Recommendation Report for Planning Permission for Works or Extension to a Dwelling

REF NO: M/42/15/HH

LOCATION: 37 Lane End Road
Ancton
Middleton-on-Sea

PROPOSAL: Side & rear single storey extension (resubmission following M/10/15/HH).

OCK PLAN 1/500

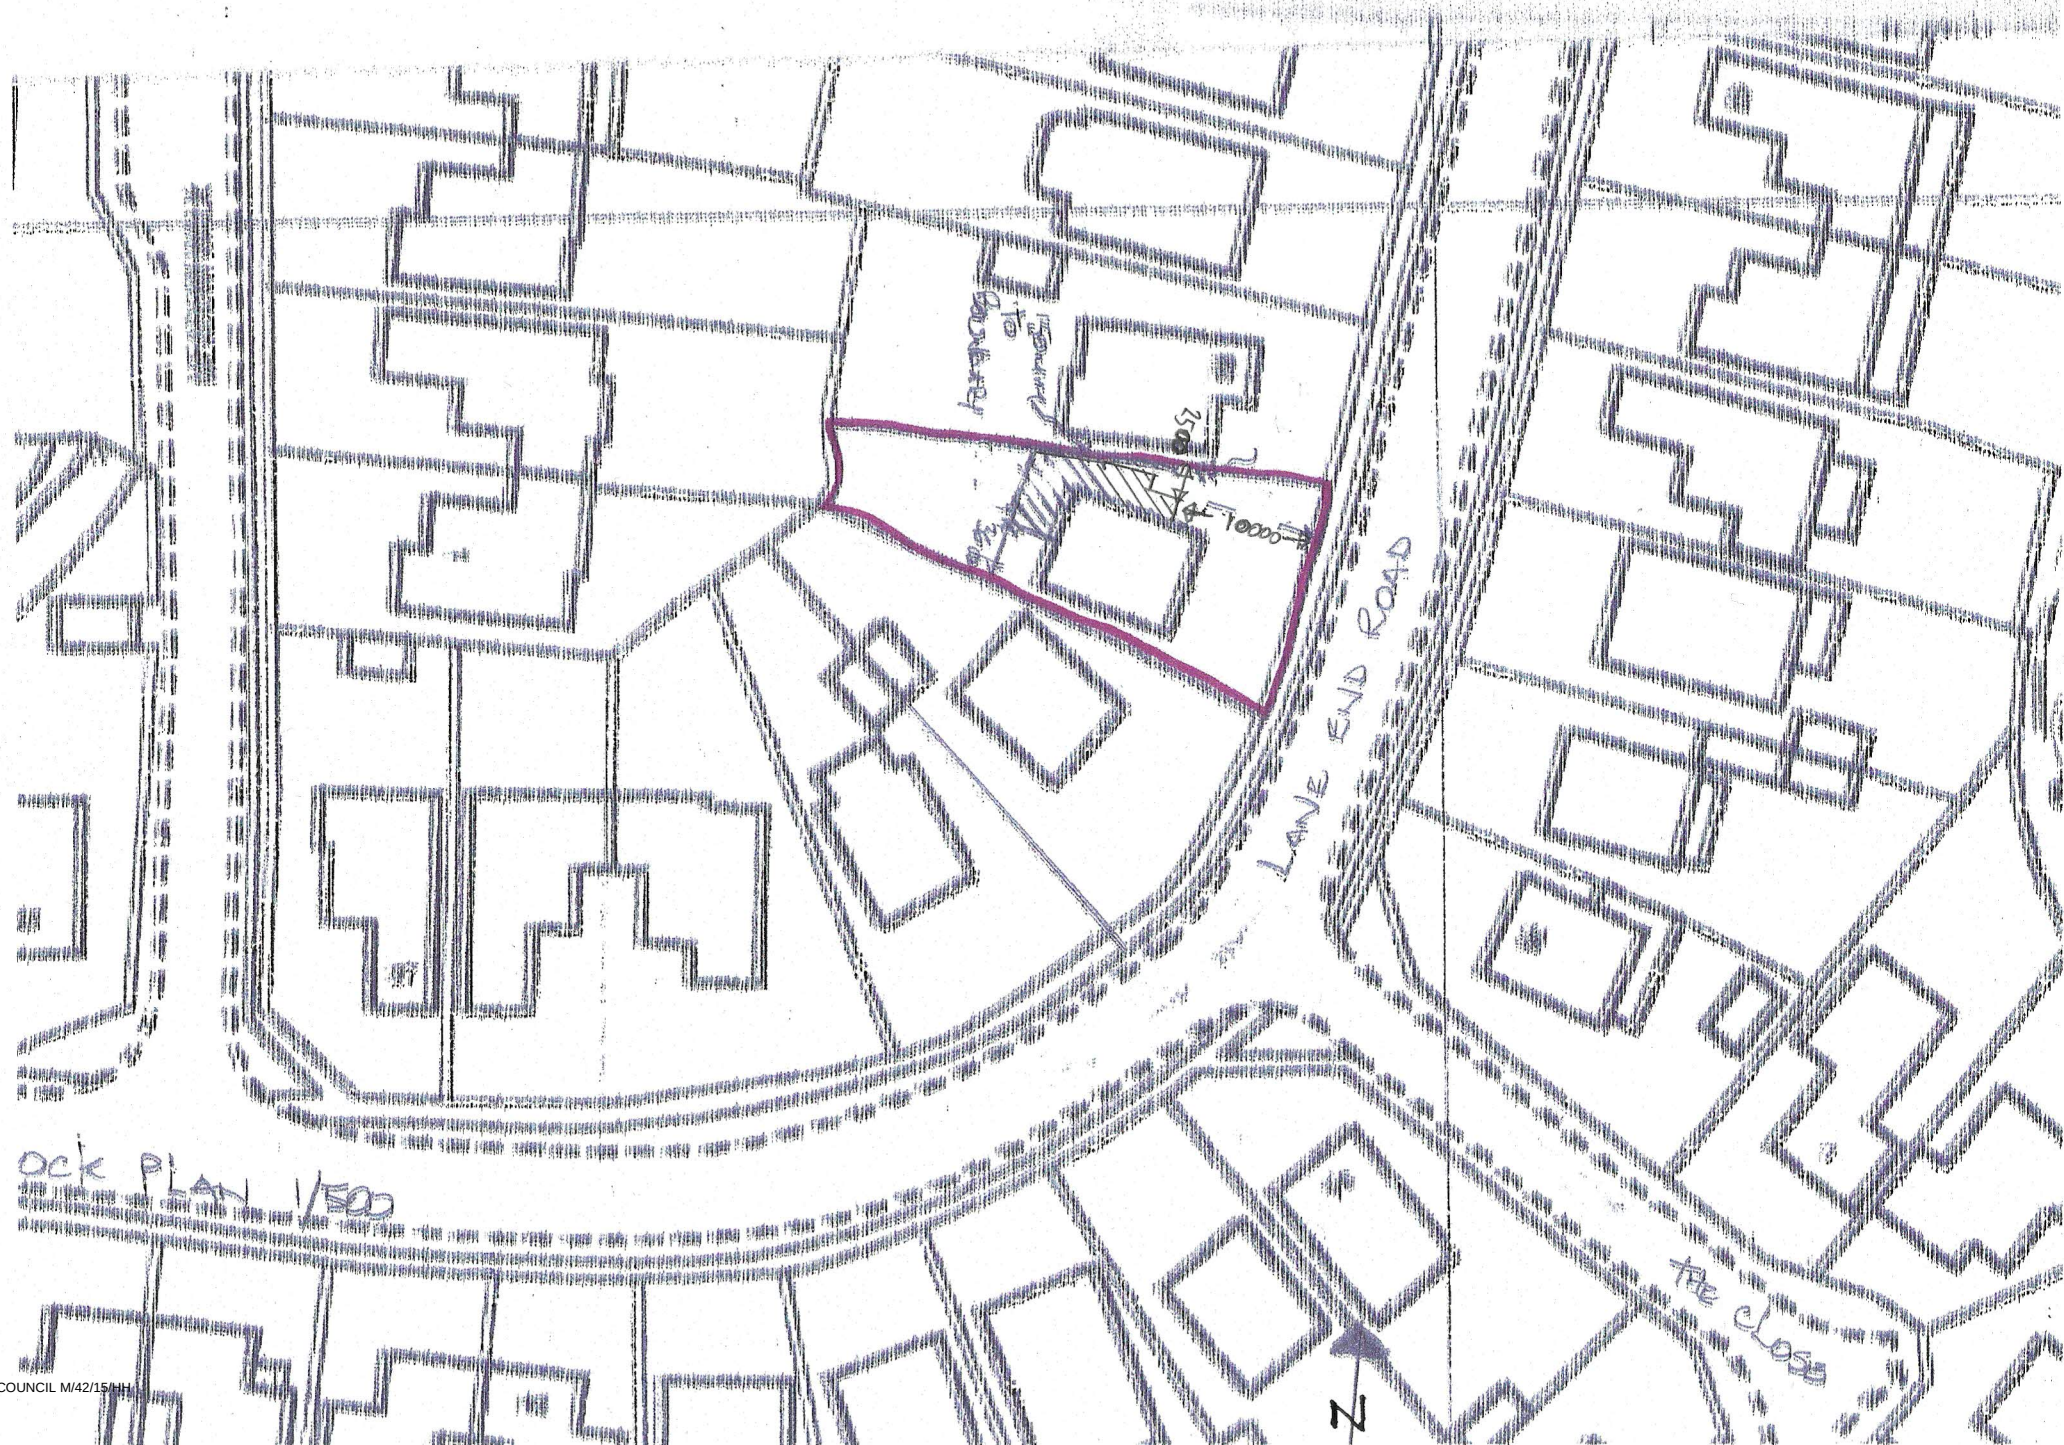
The proposed has however been revised to be located further away from the boundary with the adjoining dwelling and the front wall has been moved back to be 2.9m from the front of the dwelling. The first 2.35m depth of the extension has been limited to 1.367m in width out from the side of the existing dwelling. This element will be between 2.0m and 2.5m from the side boundary.

PROPOSED GROUND FLOOR PLAN 1/50

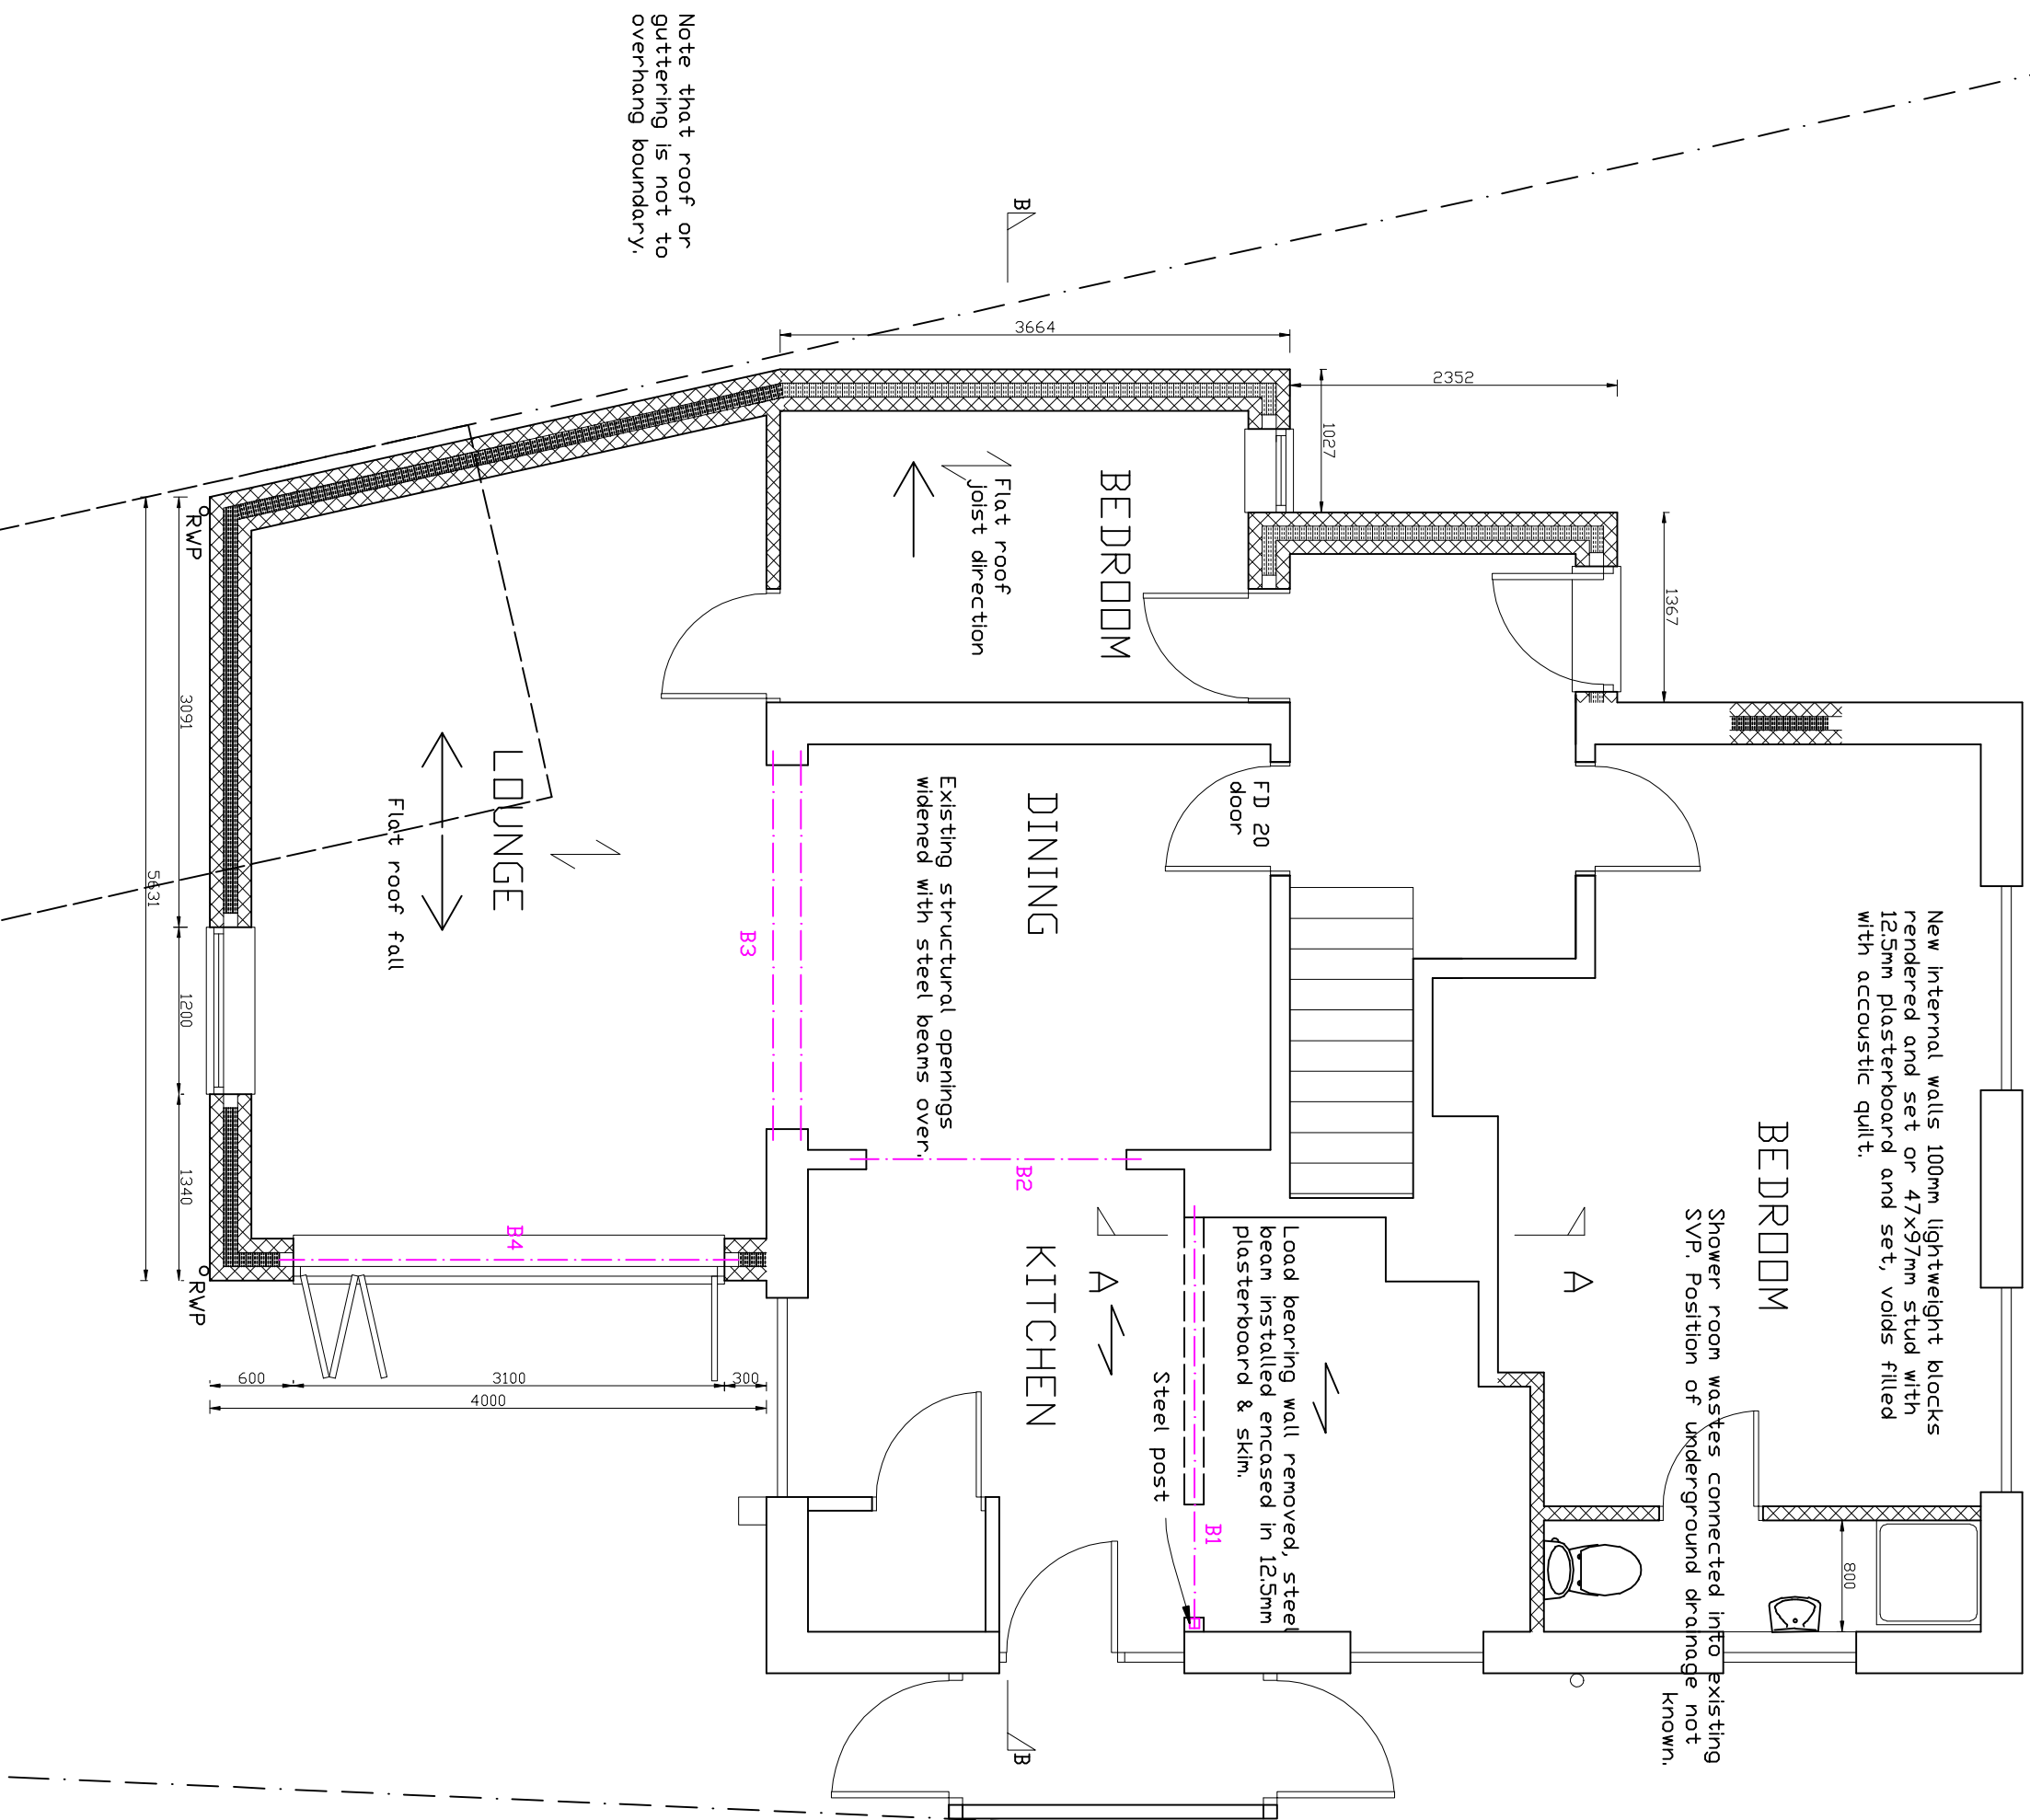
The next 3.66m depth of the extension is stepped outwards by 1.02m and would be 0.9m from the side boundary falling to 0.1m at the rear of this element. A further rear side element of the proposed Lounge extension is 4.2m deep along the boundary. The proposed extension still incorporates a flat roof and would still not extend further back than the existing garage on the boundary, which extends a further 3m on the boundary at the present time.

The front wall has been moved back to be 2.9m from the front of the dwelling. The first 2.35m depth of the extension has been limited to 1.367m in width out from the side of the existing dwelling. This element will be between 2.0m and 2.5m from the side boundary.

The next 3.66m depth of the extension is stepped outwards by 1.02m and would be 0.9m from the side boundary falling to 0.1m at the rear of this element. A further rear side element of the proposed Lounge extension is 4.2m deep along the boundary. The proposed extension still incorporates a flat roof and would still not extend further back than the existing garage on the boundary, which extends a further 3m on the boundary at the present time.

It is considered that the revised scheme ensures that impact on light has been limited to an acceptable level and that the extension will not now be unduly dominant. There is considered to be no significant harm to residential amenity such that refusal of planning permission would be justified.
